20/12/23 - HCL mark-up

Talbot Gardens, Plymouth
Block A Plans (2 of 4)

Title
 Level 00 - General Arrangement

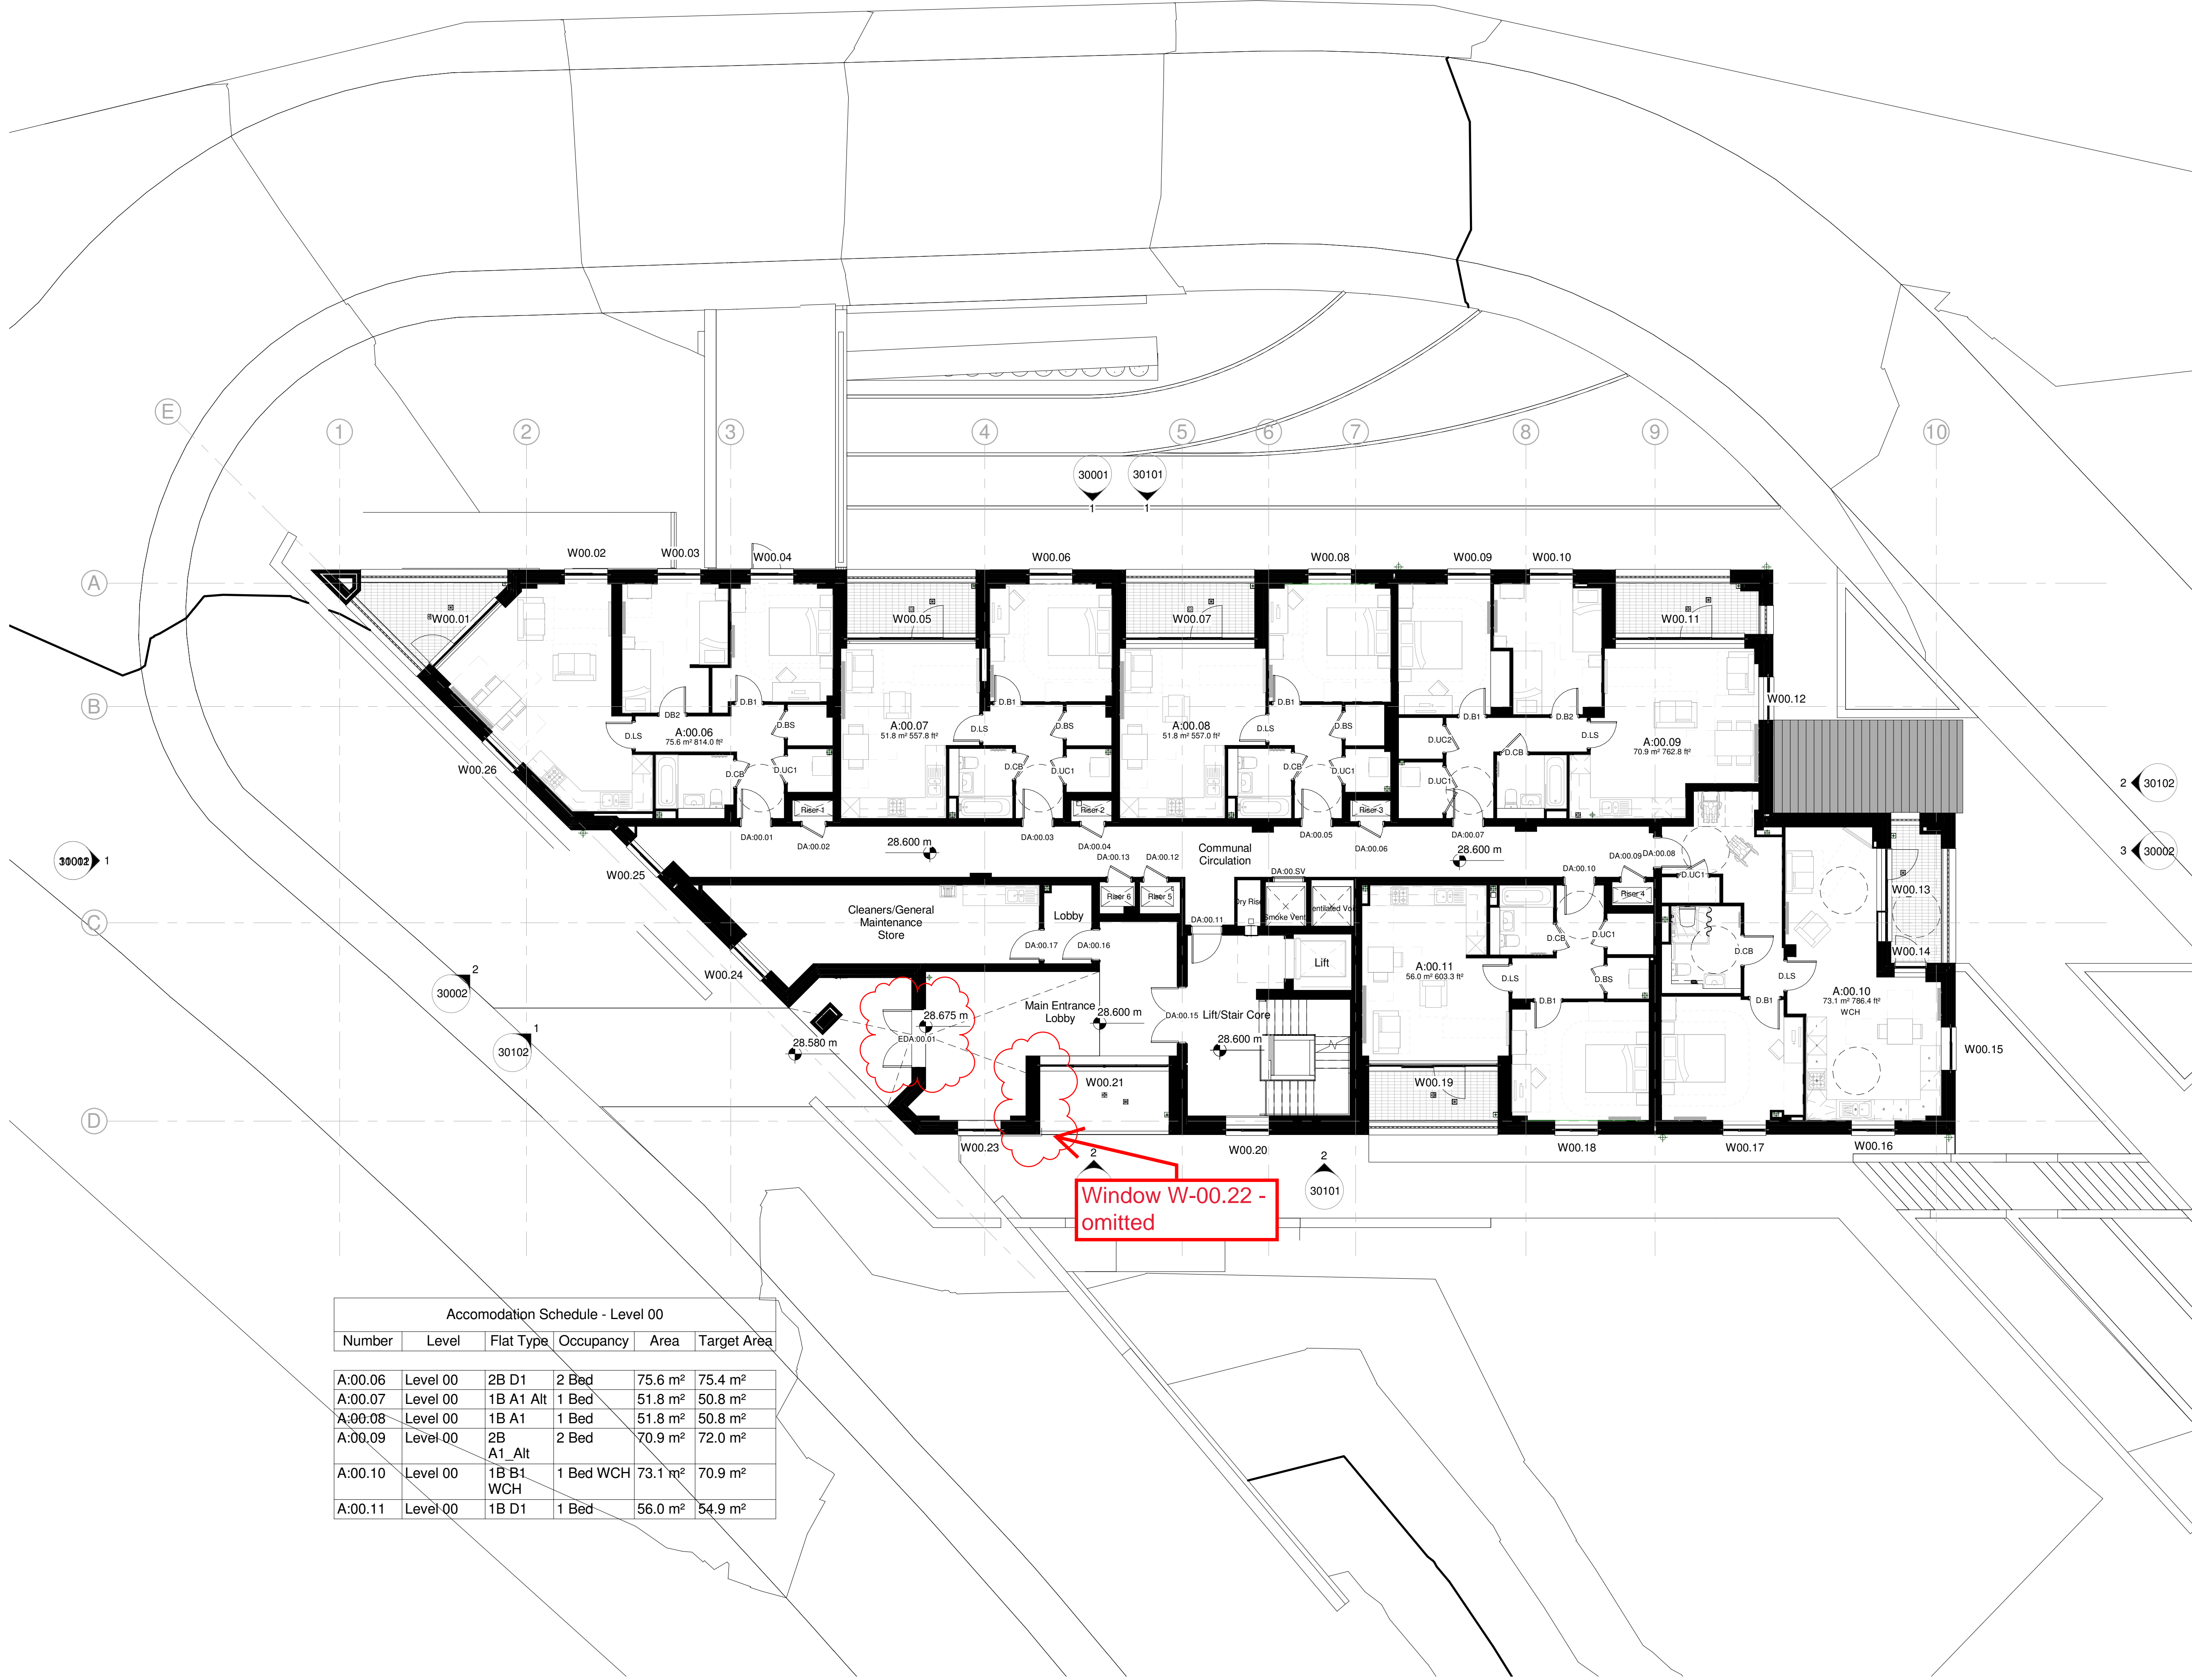
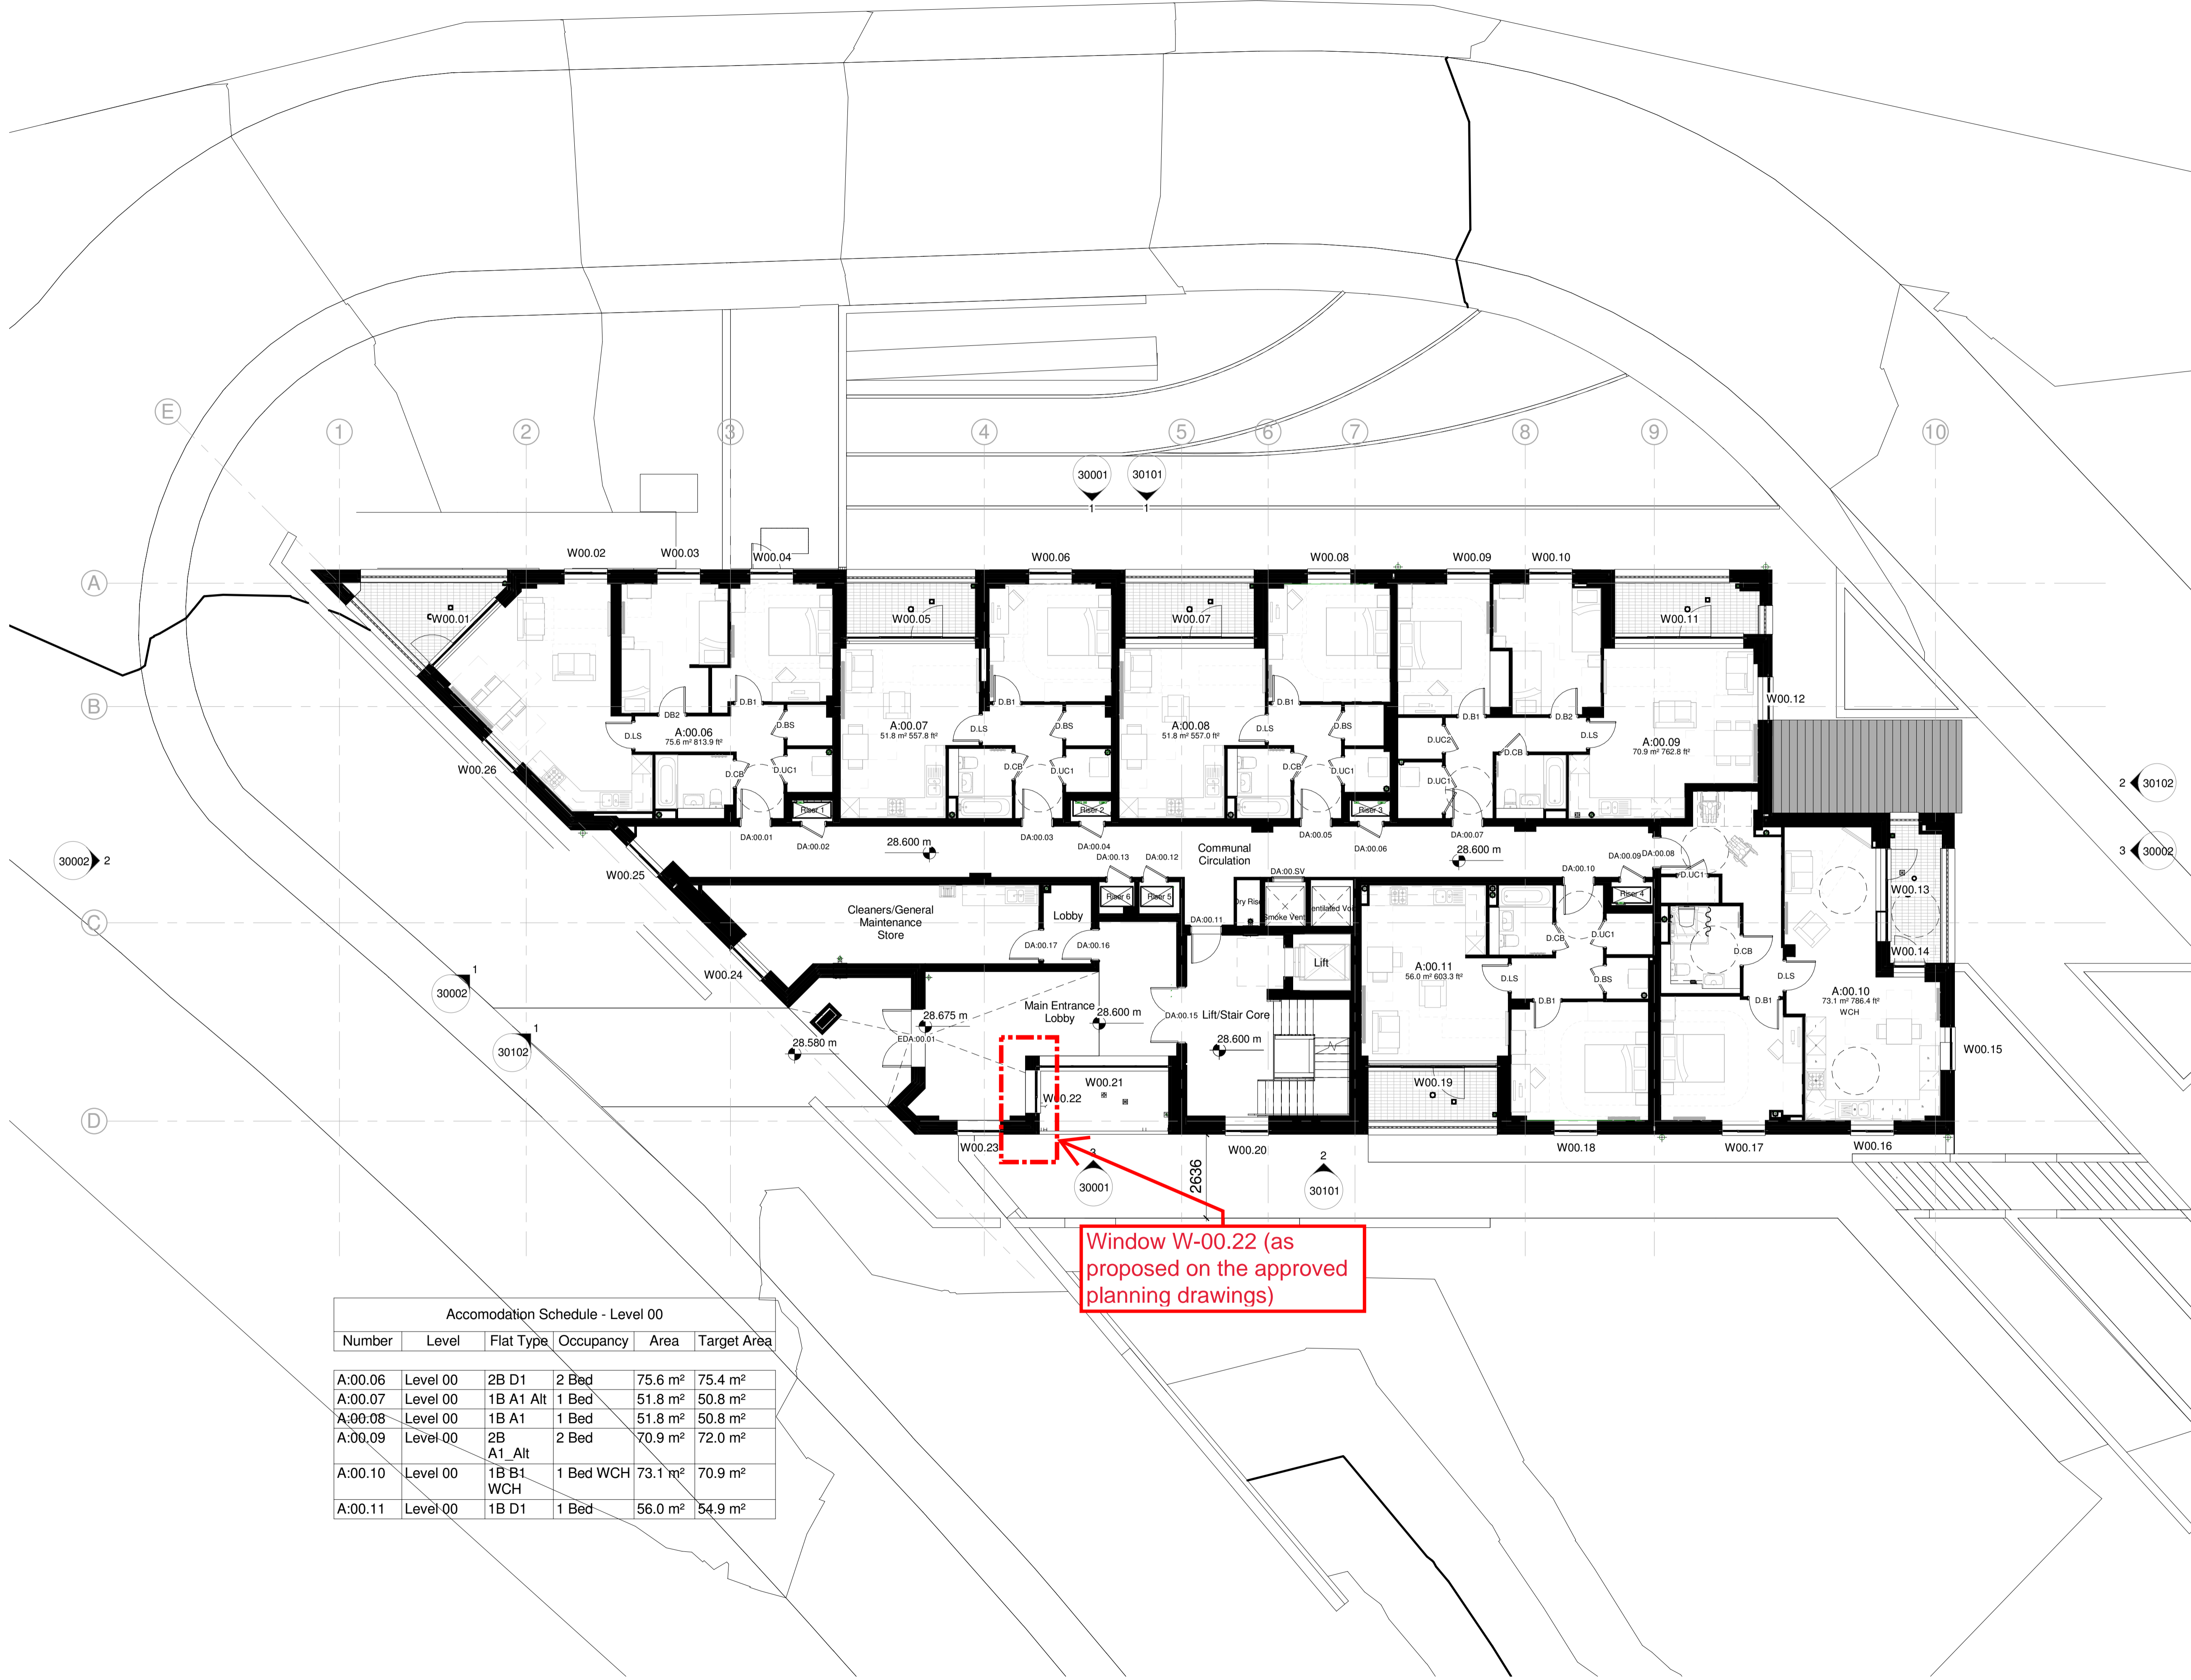
Window W-00.22 (as referenced on the construction drawings from AWW Architects)
